Application No: BR/2/26/PL

### Recommendation Report for Planning Permission

LOCATION: 37 Glamis Street  
Bognor Regis  
PO21 1DJ

PROPOSAL: Conversion of existing dwelling into 6 bedroom, 10 person HMO. This application is in CIL Zone 4 (Zero Rated) as other development.

PROPOSED
REAR ELEVATION

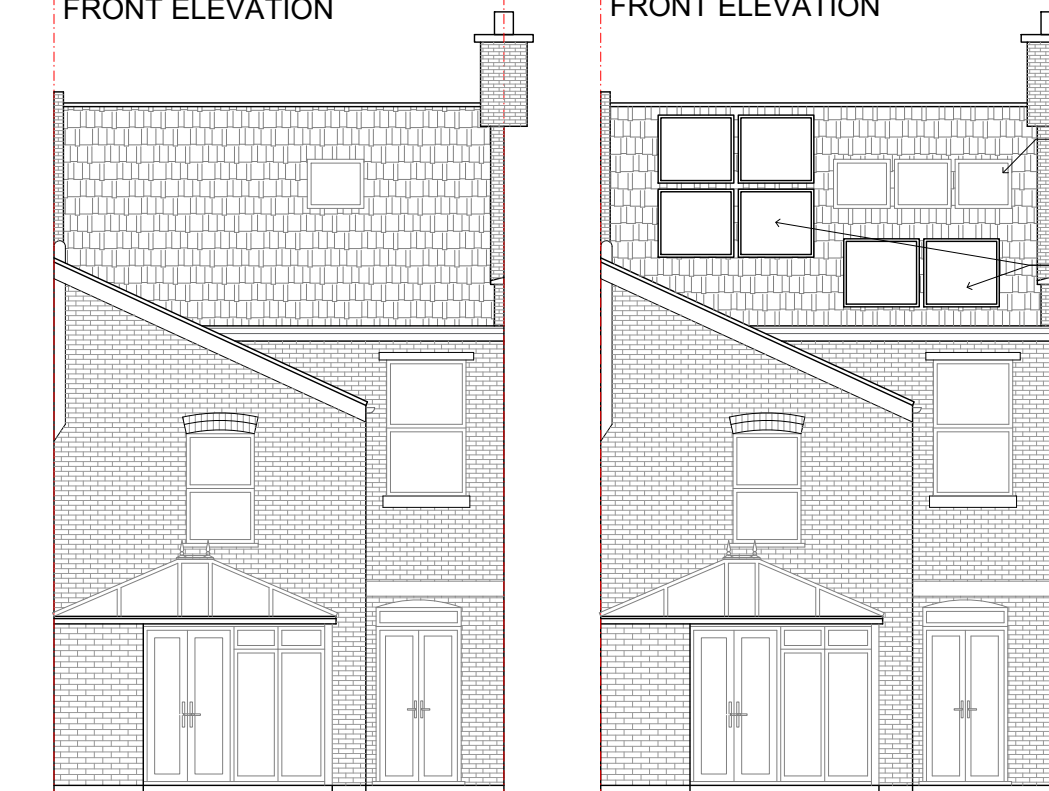
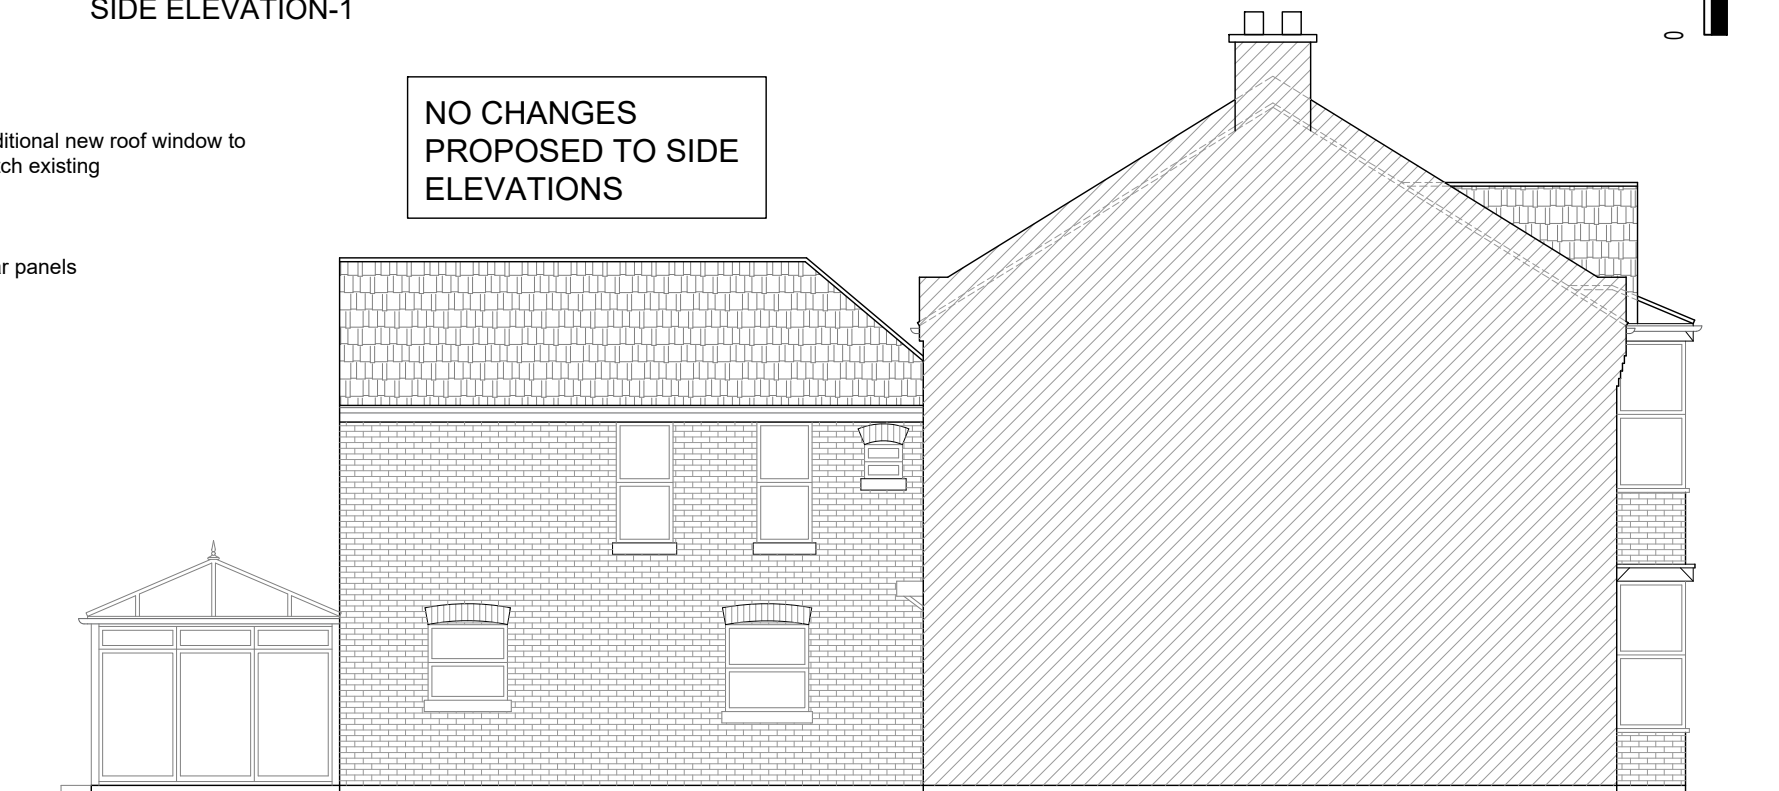
The proposal involves the installation of two rooflights and solar panels on the rear roof slope and otherwise would not alter the external elevations. On this basis, the proposal would not directly or indirectly prejudice the heritage assets in question or their settings.

PROPOSED ROOF PLAN

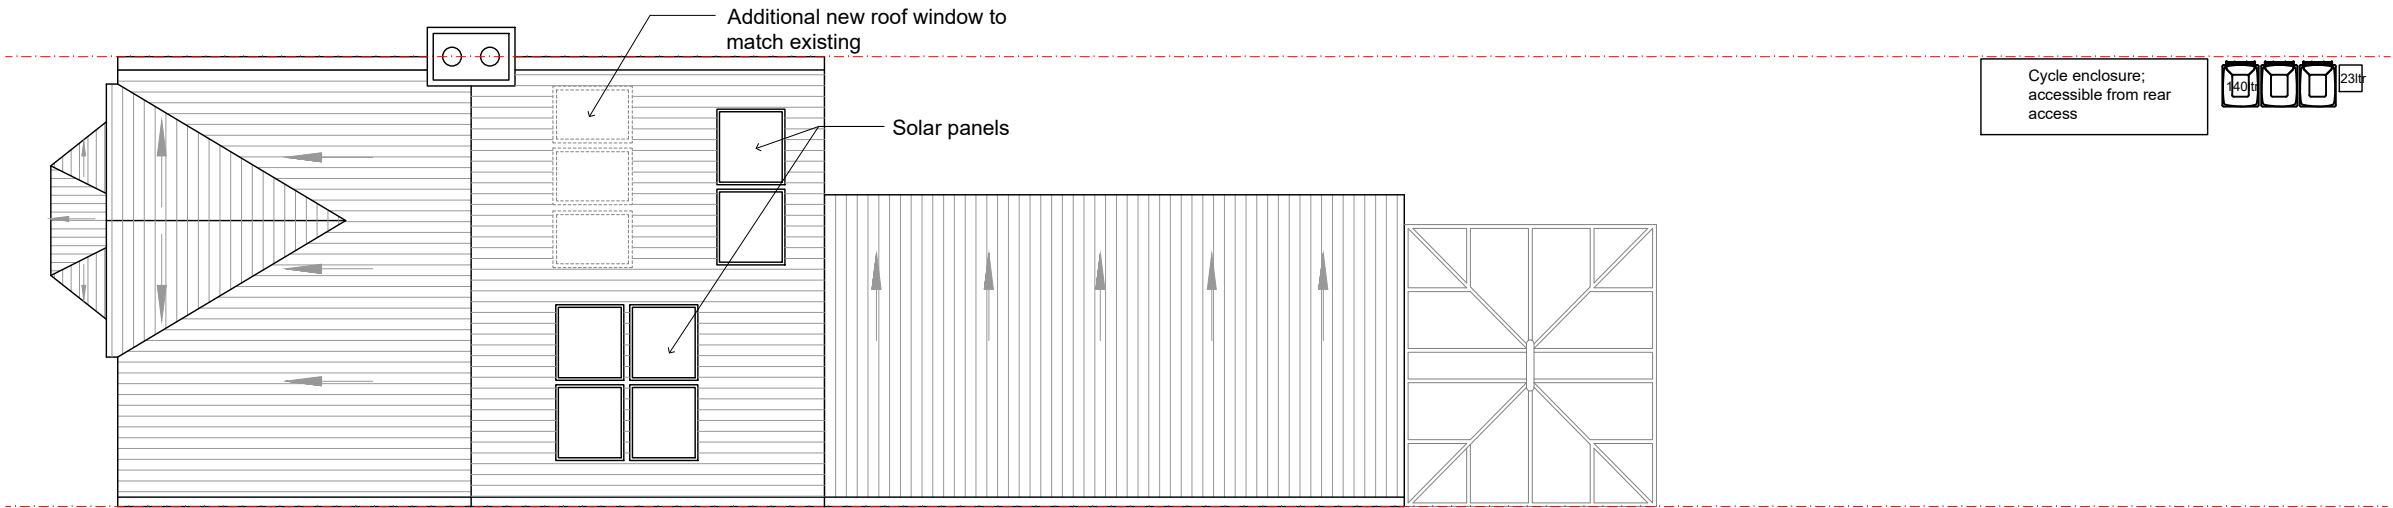
The proposal does not benefit from any car parking provisions but is to provide 6 cycle storage spaces in the rear garden, which will be secured by way of condition.

- 3 No part of the development shall be first occupied until covered and secure cycle parking spaces have been provided in accordance with the approved 'Block plan' (A2025074.PA109, P01) and 'Roof Plan' (Including cycle storage details, A2025074.PA105, P01). The spaces so provided shall be retained in perpetuity.

Assessment of the ratio of HMOs to independent residences within 250m radius at the time of the application

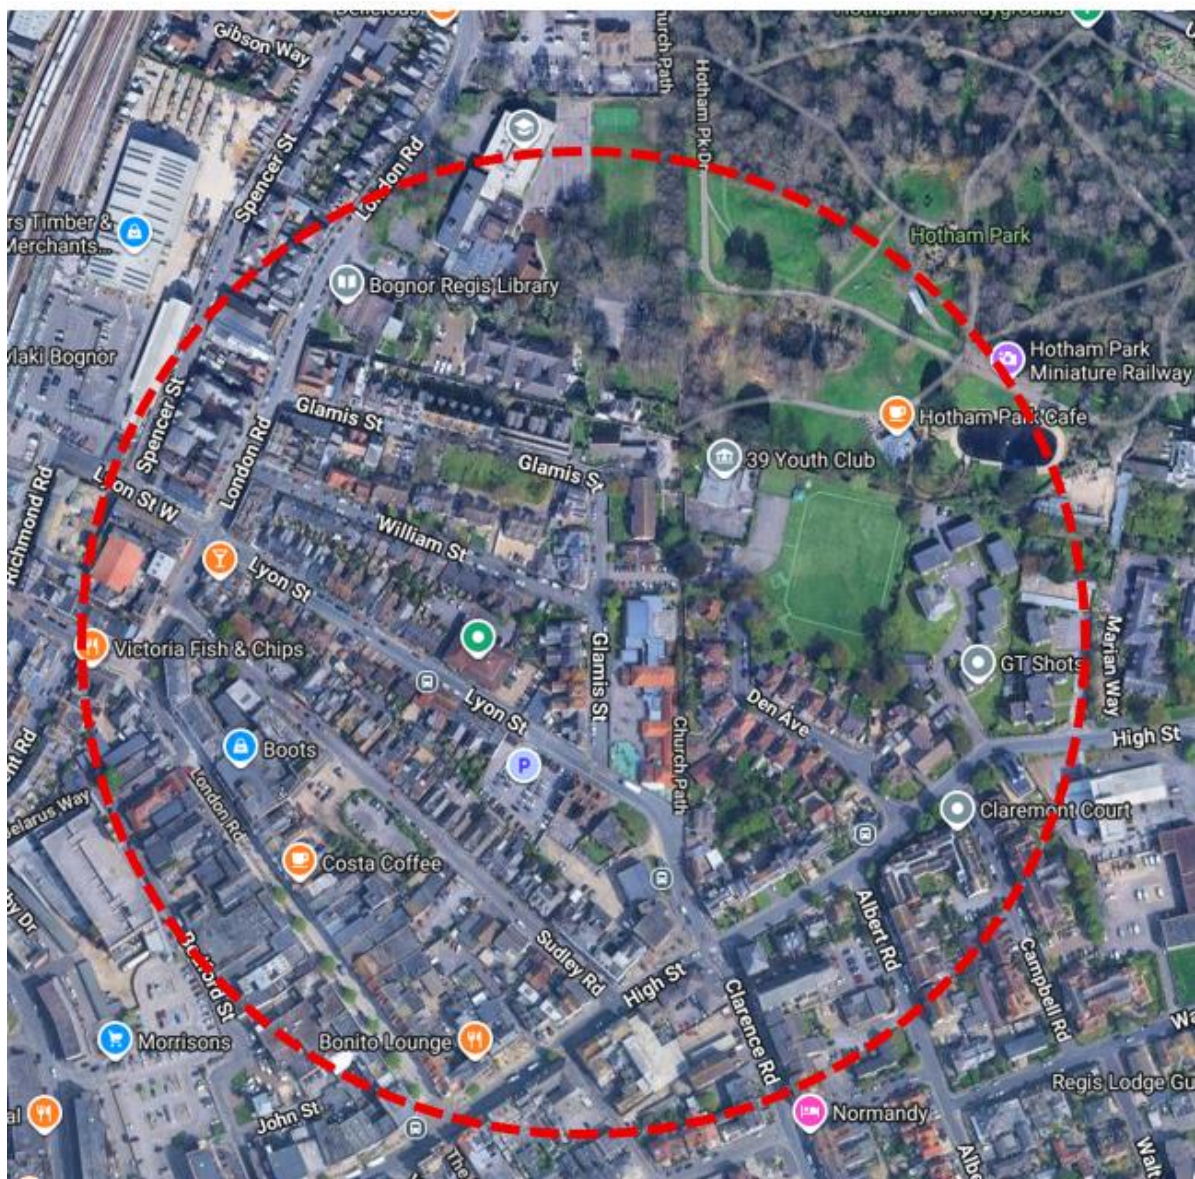
For consistency with previous appeal decisions, officers have undertaken an assessment of HMO numbers within a radius of 250m of the site and to provide an objective assessment relevant to this site. There are 852 residential properties within a 250m radius of the site, and 25 of these are recorded as active HMOs. The ratio of HMOs to independent residential units within 250m of the site is 2.9%.
